SYDNEY SWANS HQ & COMMUNITY CENTRE ROYAL HALL OF INDUSTRIES

RESPONSE TO GA NSW PLANNING SUBMISSION

October 2019

This report is a response to the 'outstanding concerns' raised in the letter written by the Government Architect of New South Wales (GA NSW) to the NSW Planning Department with regards to the Adaptive Reuse of the Royal Hall of Industries (dated 7 August, 2019)

Figure 16 | Mezzanine layout (Source: Applicant's Design report).

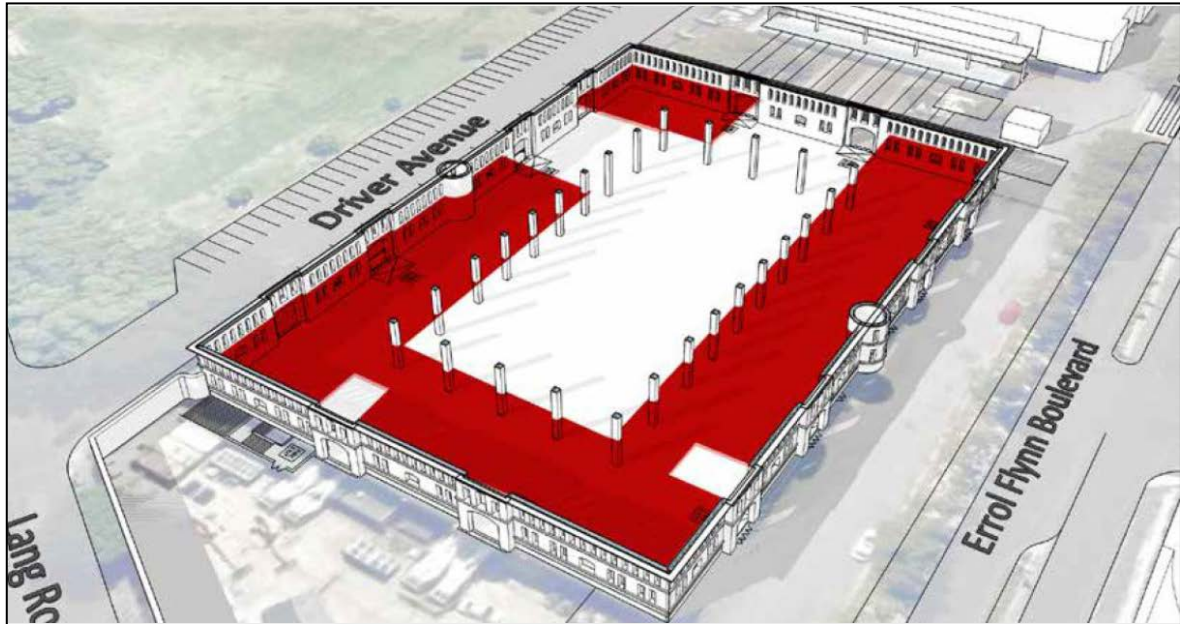
Provide a clear philosophy/language for the internal architecture to ensure it reads as a respectful and reversible insertion into the existing RHI.

Around the perimeter of the central hall, the development proposes the construction of a new mezzanine to increase usable floor space to accommodate the required new program.

The mezzanine will be structurally independent of the existing RHI building lightly touching the existing fabric. The columns for the new mezzanine are new and separate to the existing columns and can be removed at the completion of the lease with limited impact to the existing slab and foundations.

Figure 17 | Images showing setback of internal walls and glazing from original columns (Source: Applicant's Design report).

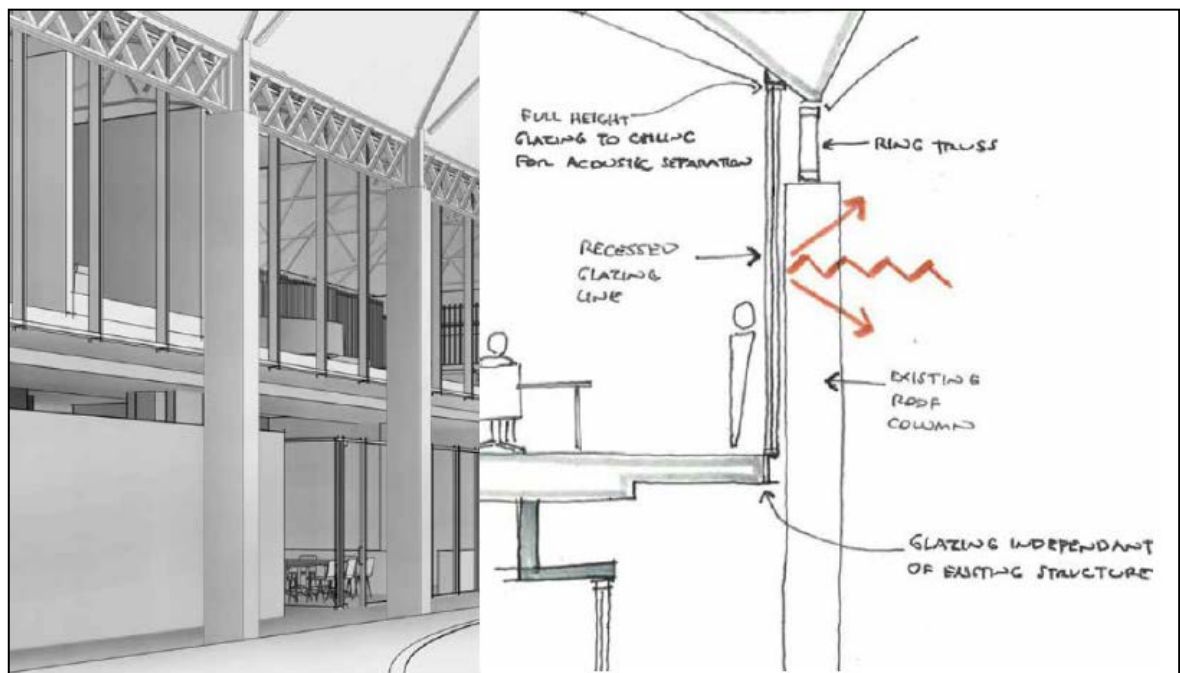
Provide a walkable space/corridor around the outside of the internal colonnade in the RHI.

A walkable corridor has been provided for the majority of the internal colonnade. The exception being the South where it was desired from the client that the building users would benefit from having access directed through the football department to encourage interaction and collaboration between coaches and players. Regardless, the layout in that area has been designed so as to align walls with columns so the colonnade is still clearly expressed (see image below).

On Level 1 the glazing is offset from the column and is viewable from a mostly continuous circulation route which guides users through the administration area through the club dining hall and to the players areas on the West. Where there are rooms adjacent to the columns instead of circulation space, glazing is offset to the column to ensure the column is visually expressed and physically independent to the new build.

The existing columns are bordered by circulation corridors for the majority of the RHI.

Figure 18 | Image showing proposed floorspace in the north west corner of the RHI (blue) (Base source: Applicant's RRFI).

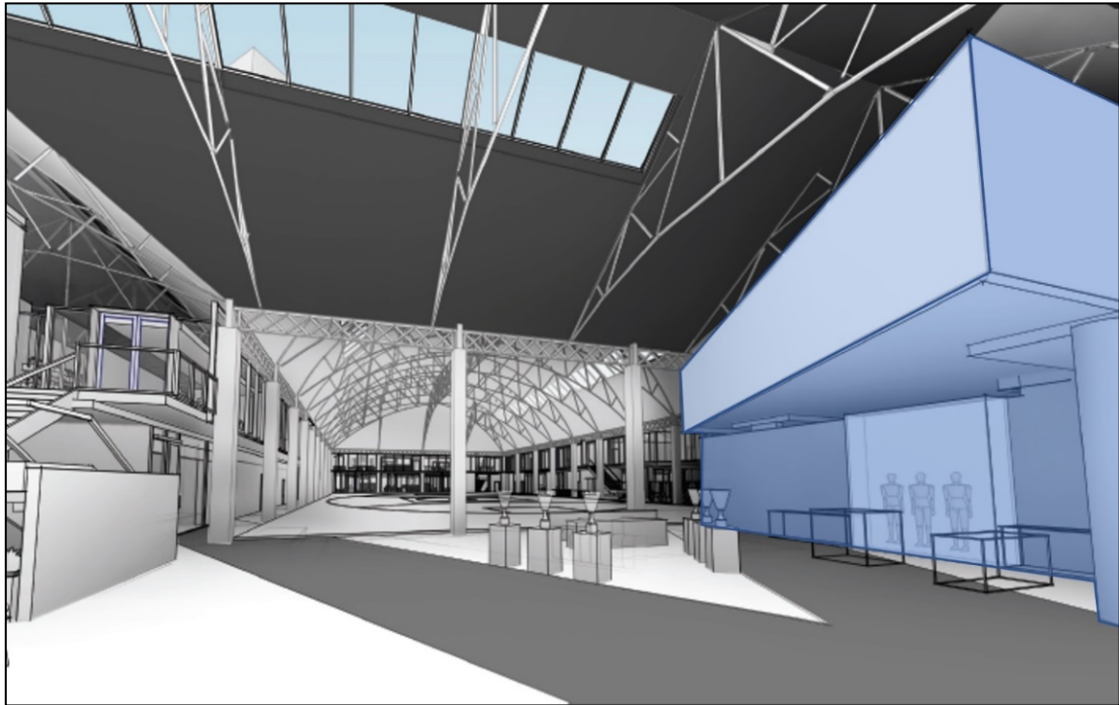
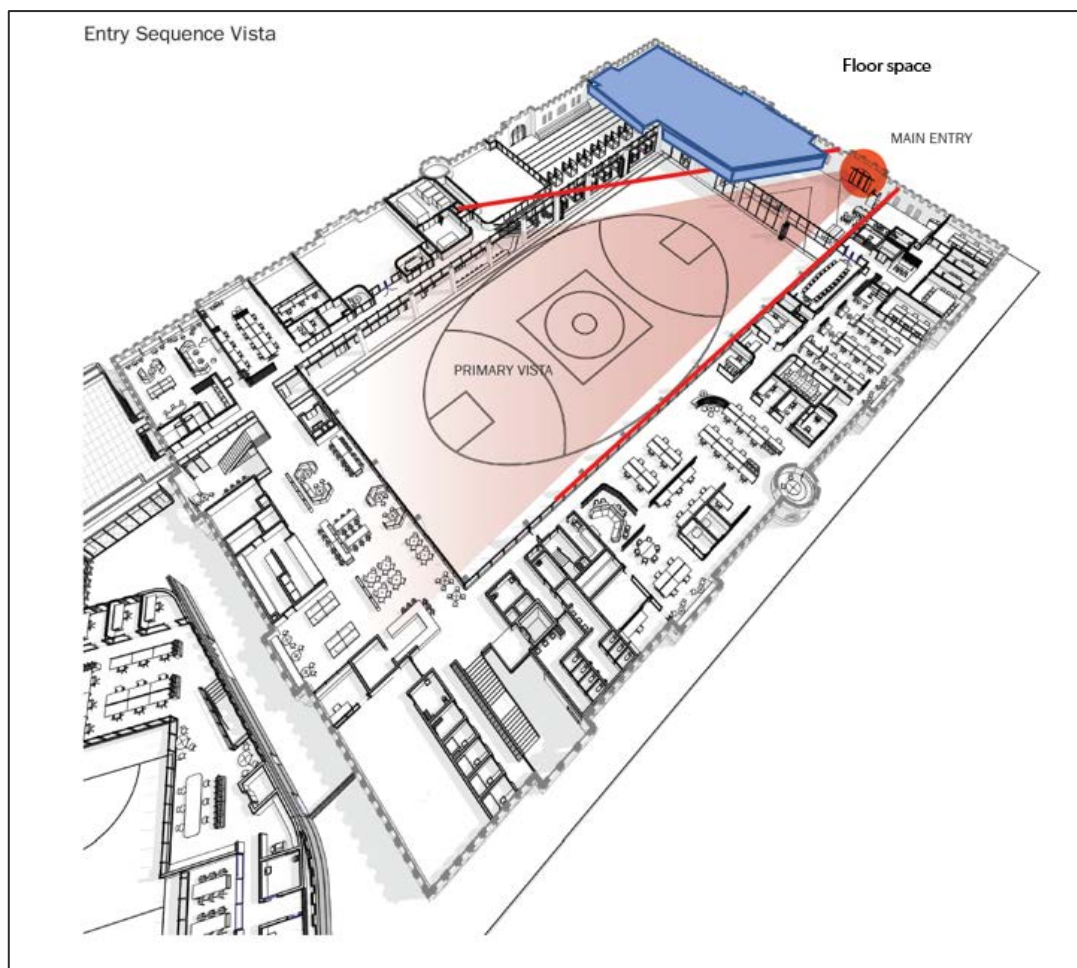
Reduce or relocate the large program elsewhere on the site, which may include within the NSB, to ensure the integrity of the RHI's heritage significance and value, and the ability to provide adequate internal public space is not affected.

We understand the 'large program' within the RHI that is of particular concern is the Commercial Tenancy area located in the North-West corner of Level 01 adjacent to the entry foyer.

The GANSW comments suggests moving this equivalent area to within the NSW Swifts Building (NSB). Given the current composition of the NSB, any relocated program could not be located within the current building and would necessitate an additional storey to this building, making it a three level building.

Our studies have found that, as a two level building, the NSB is currently appropriately sized in scale and height to respect the RHI. This composition is also supported by the landowner, CMPT, with whom we have consulted on several occasions with respect to the mass, scale and location of the NSB within this SE corner of the site.

The images to the right provide a 3D study of the potential relocation of the Commercial Tenancy program to the NSB. Another storey has been added to the current design to demonstrate how this will impact the form and massing of the NSB building (Figure 1 & 2). It illustrates that the NSB through its larger scale would become the dominant building on this site which we believe, along with CMPT, is not the preferred outcome.

We do not believe, 'the integrity of the RHI's heritage significance and value, and the ability to provide adequate internal public space', has been affected by the insertion of this commercial tenancy program in the current NW Level 01 location.

Figure 21 | Axonometric view of the proposed NSW Swifts building illustrating the relationship with the RHI from the north (above) and south (below) (Source: Applicant's RtS).

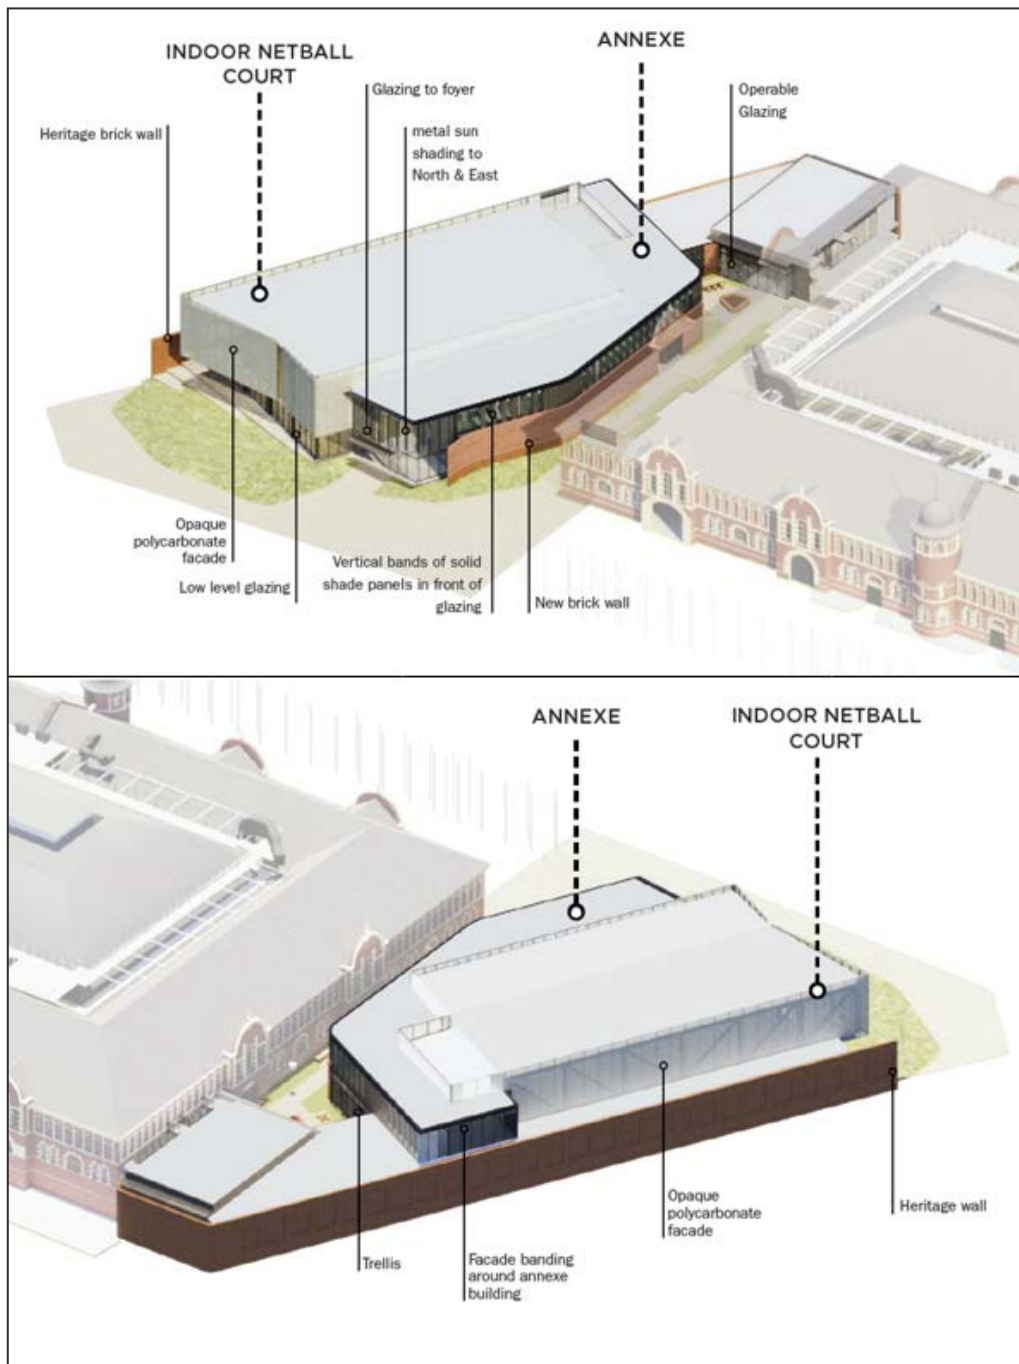
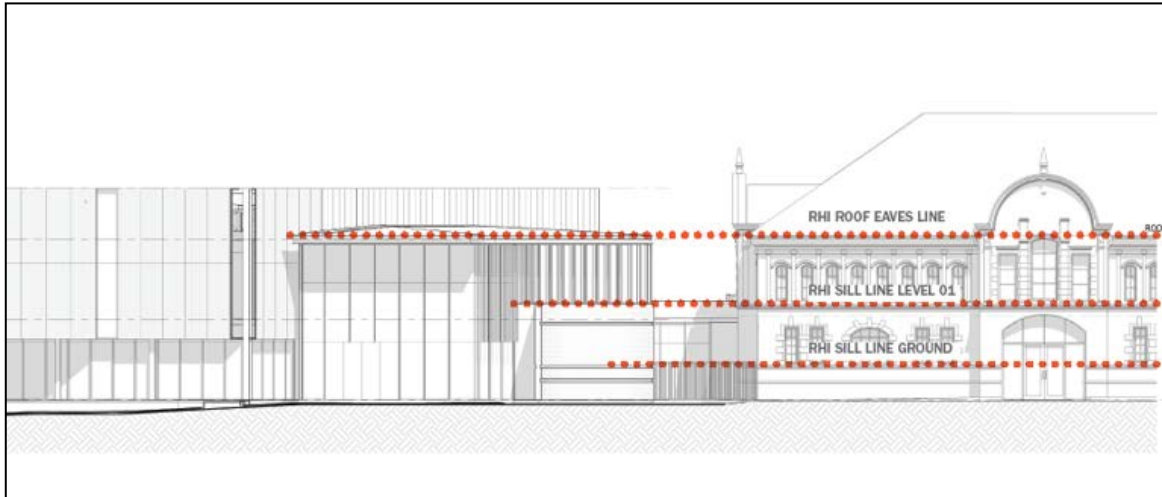
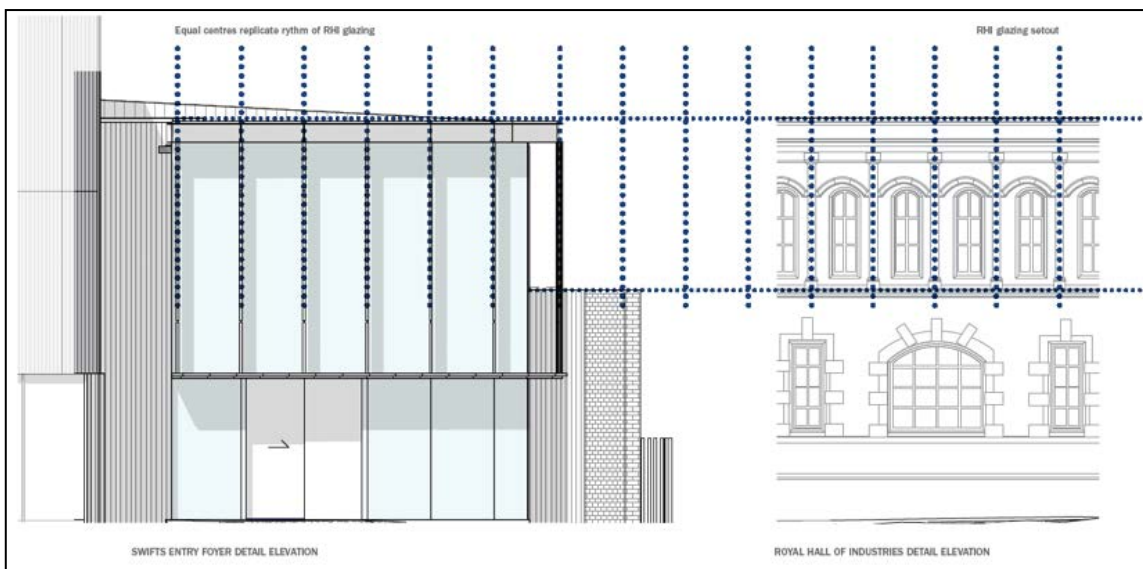
Articulate the façade of the NSB to reflect its corner location and entrance to the greater site.

The facade of the NSB is articulated with consideration to its corner location on Lang Road and Errol Flynn Boulevard and its location neighbouring the RHI.

Sight lines and setbacks were set from the beginnings of the design process to ensure the NSB design was respectful to its context (see plan below) Heights of the building mass were strategically chosen to mimic

existing RHI horizontal datum lines.

Further to this, the Northern shading panels facing the RHI follow the 1200mm centre to centre window rhythms of the RHI. The Southern facade of the NSB facing the parklands is a poly carbonate facade which is a plain facade during the day and a simple light box in the evening. This poly carbonate turns the corner onto the facade of Errol Flynn Boulevard. This design move is intended to enhance the arrival experience from Lang Road onto the entrance to the greater precinct.
